Proposed Addendum 06 – POST BIDDate: April 16, 2004

Regarding: **Logan Place SRO Apartment – Bidding Documents**Subject: **Proposed Addendum 06**

The following addendum items apply to the project known as the **Logan Place** located in Portland, Maine.

**A7.14** DETAIL @ CORRIDOR / STAIR WALL  
SCALE: 1 1/2" = 1'-0"

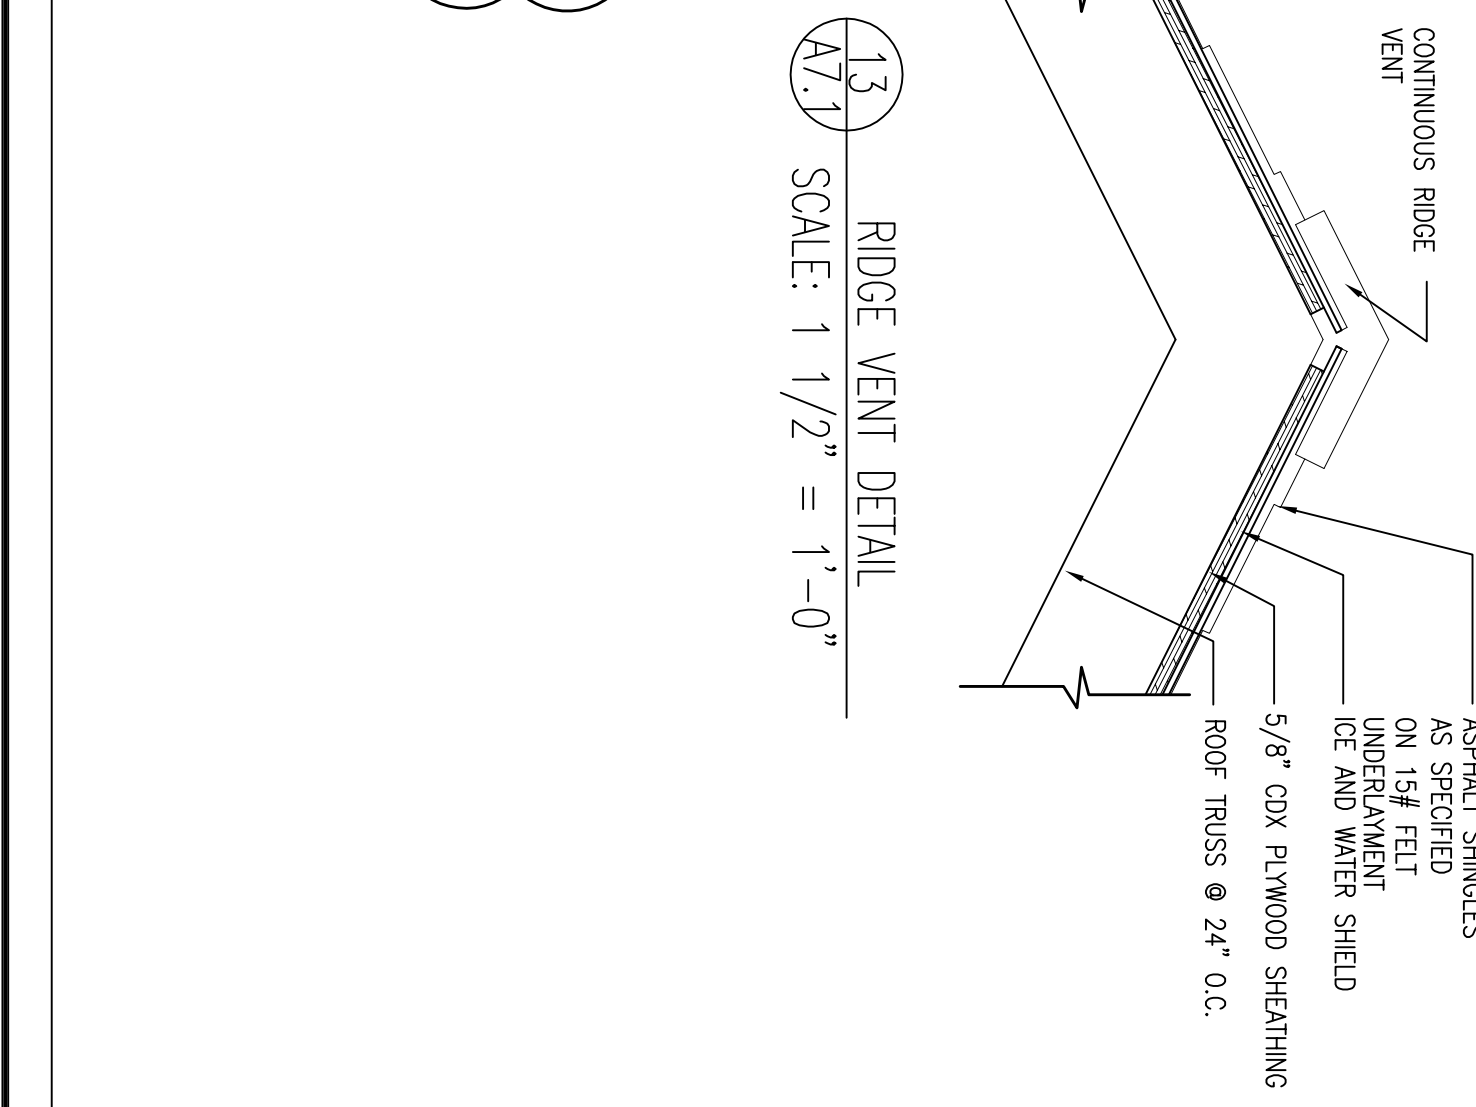
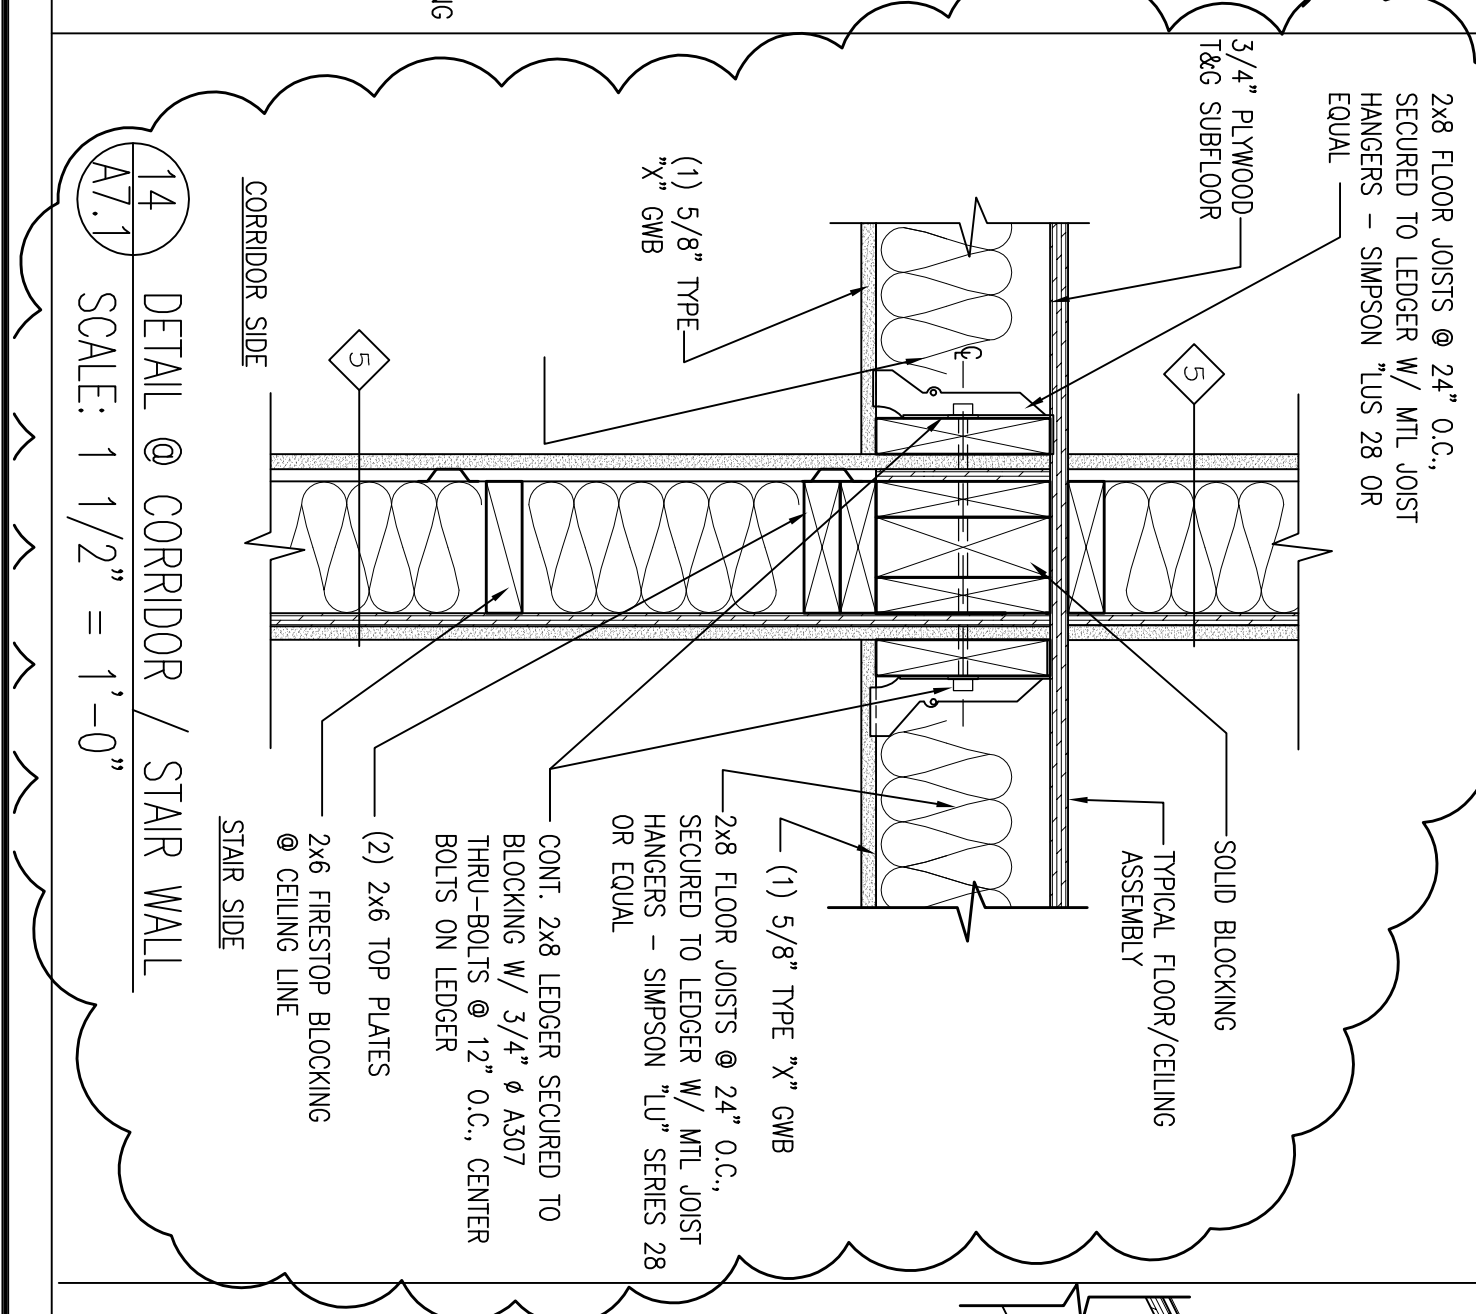
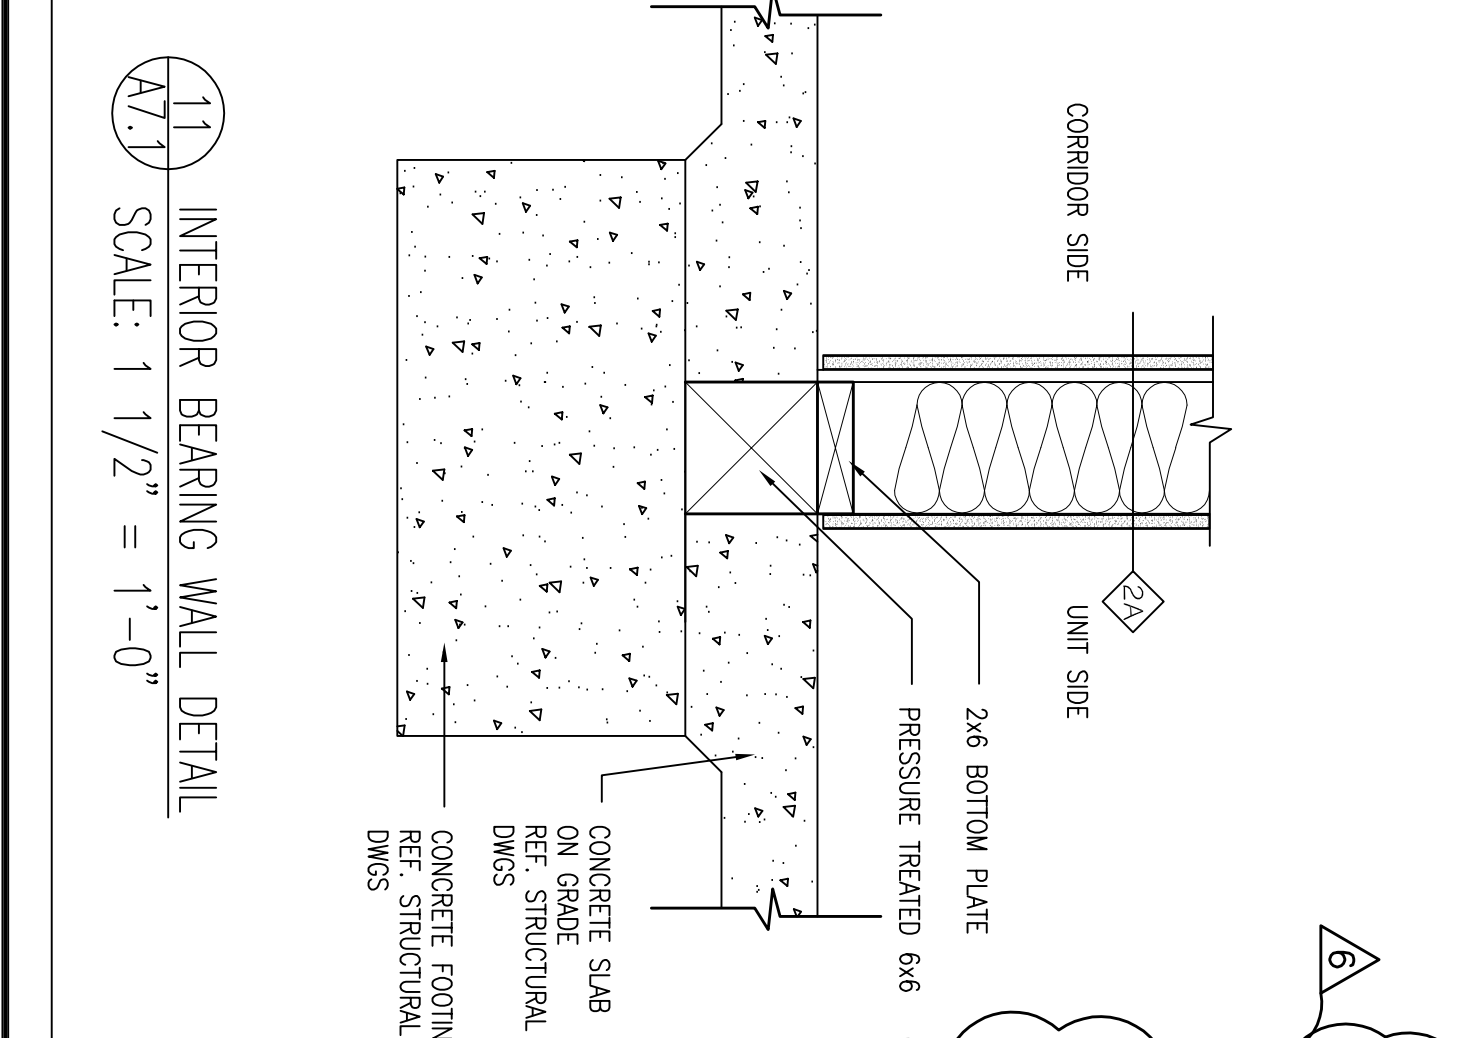
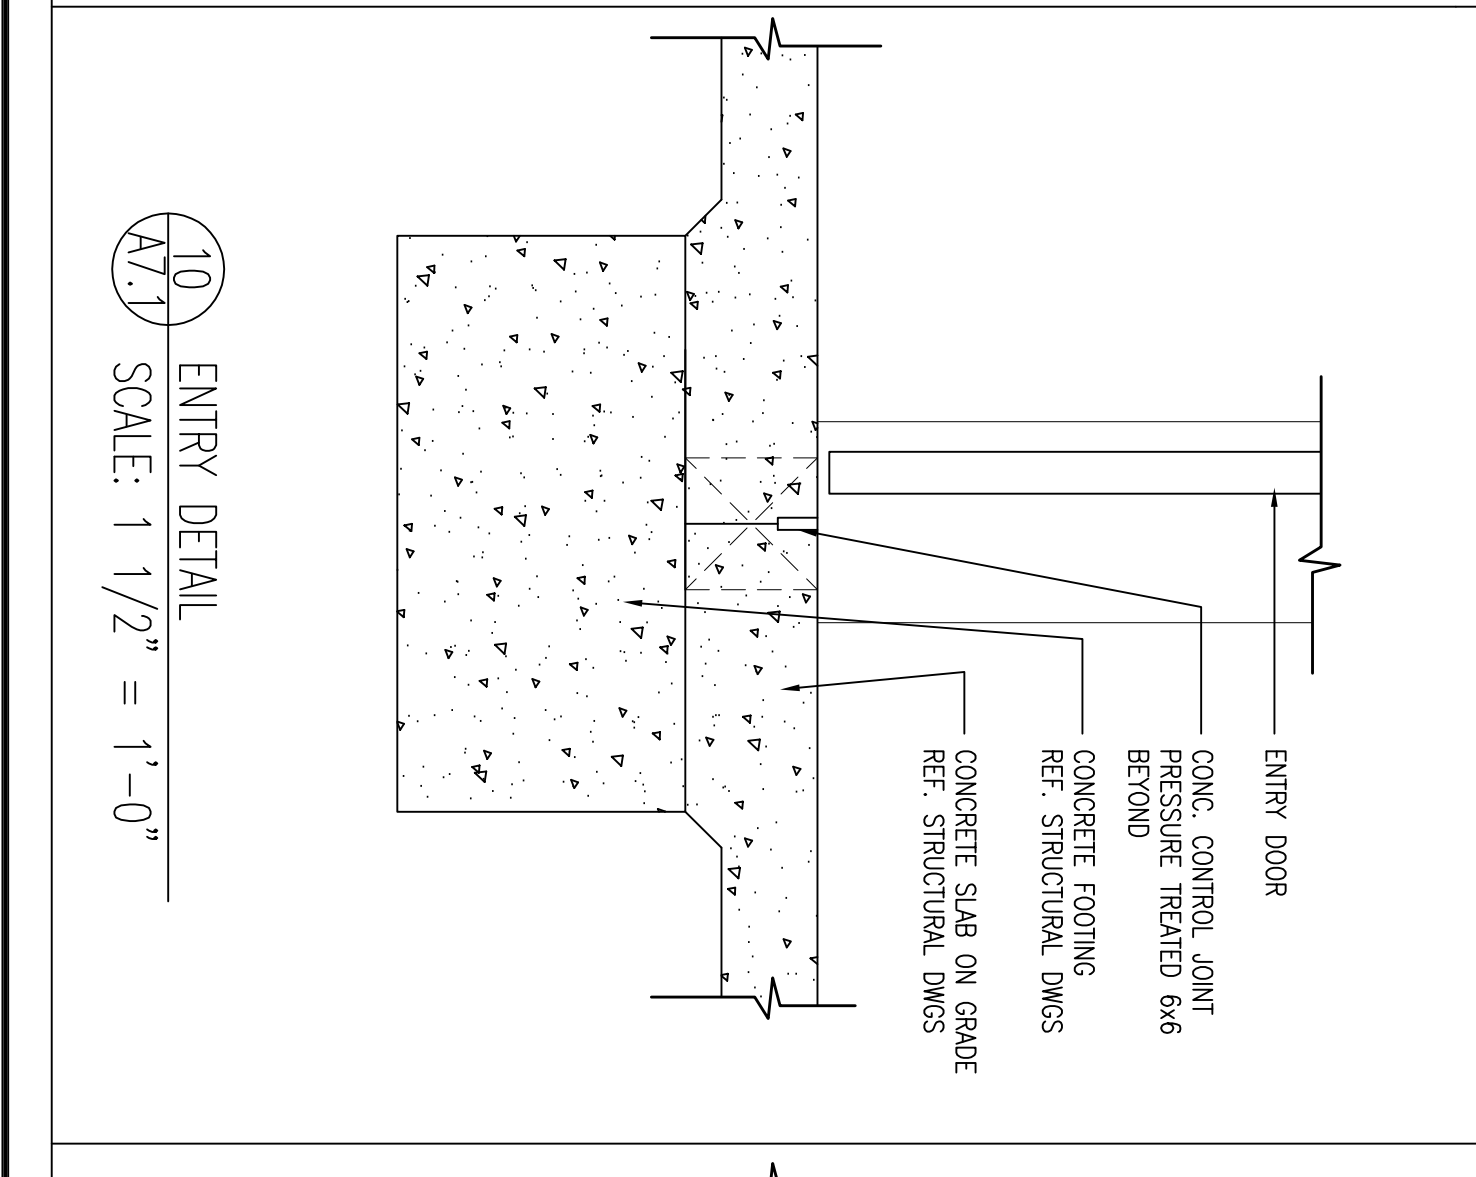
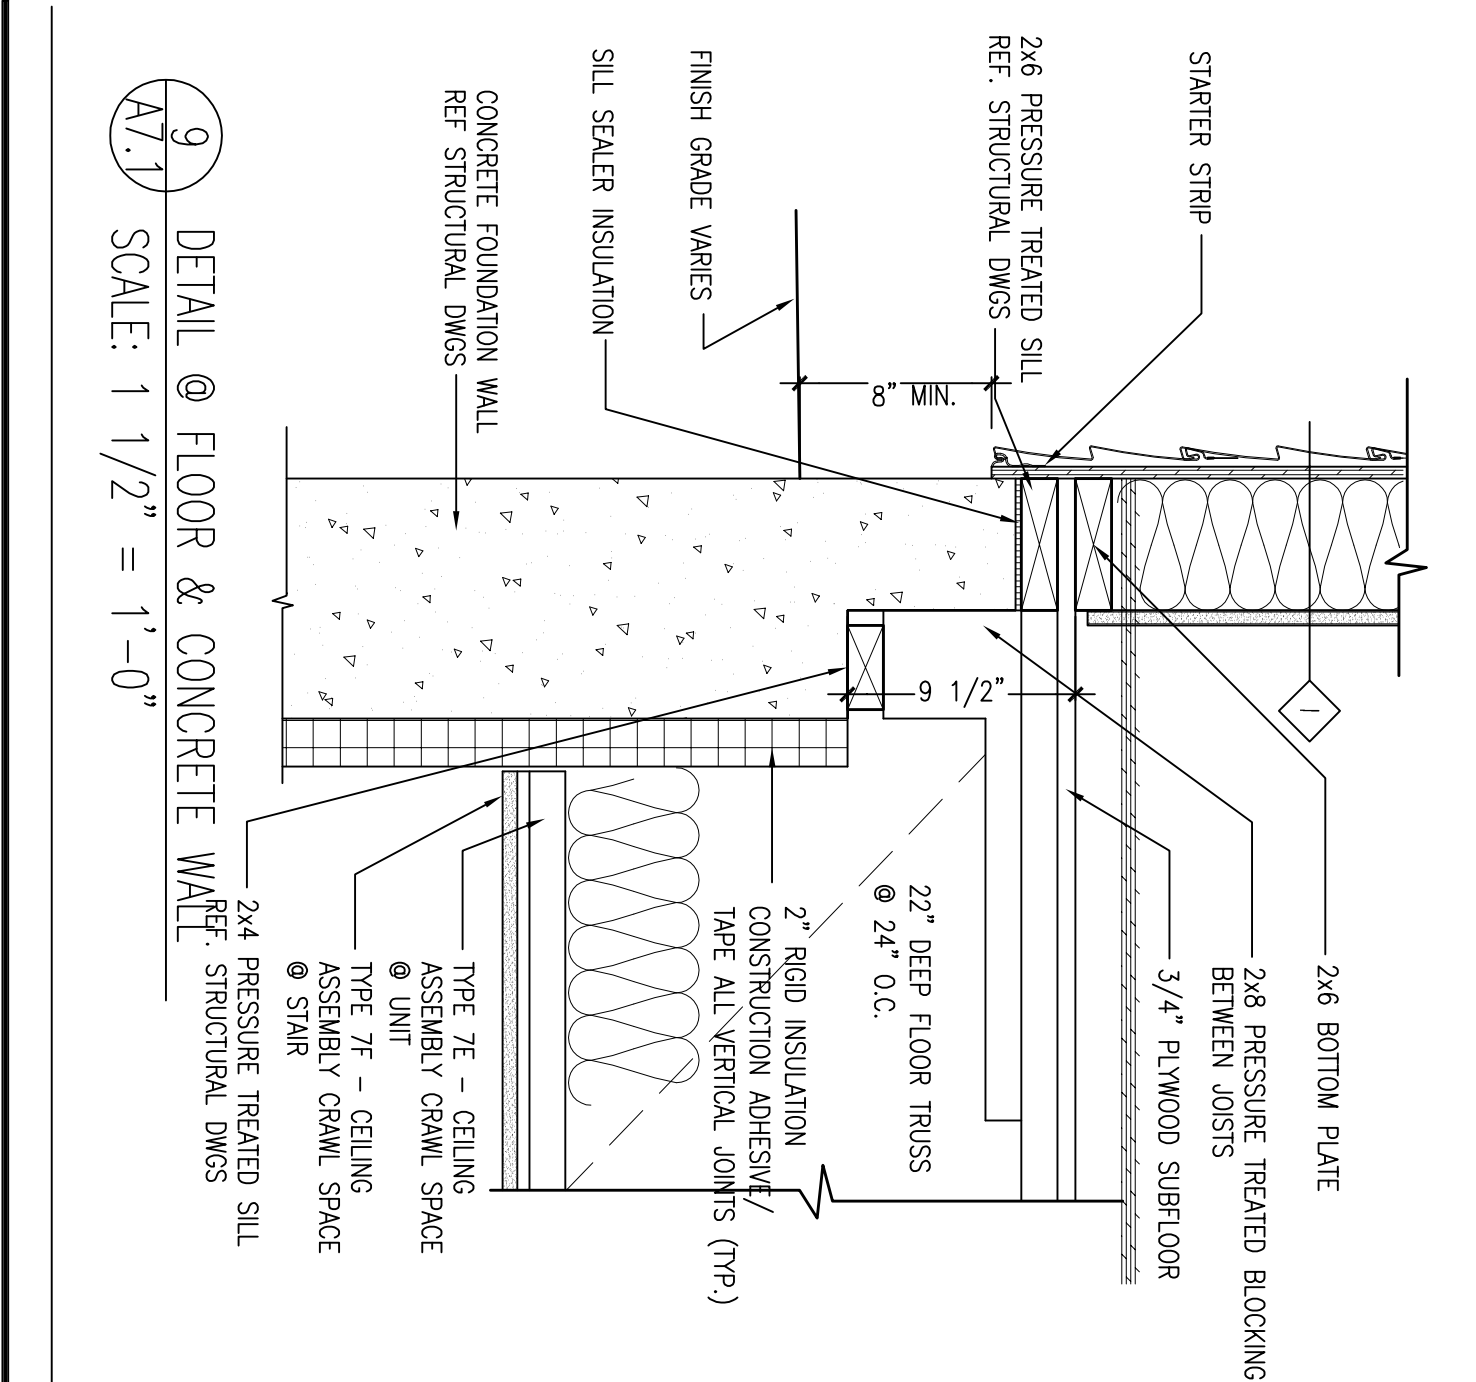
6. See revised drawing A5.1 for revised Stair Section C – indicated with revision cloud.
7. See revised drawing A7.1 for added new detail 14 – indicated with revision cloud.
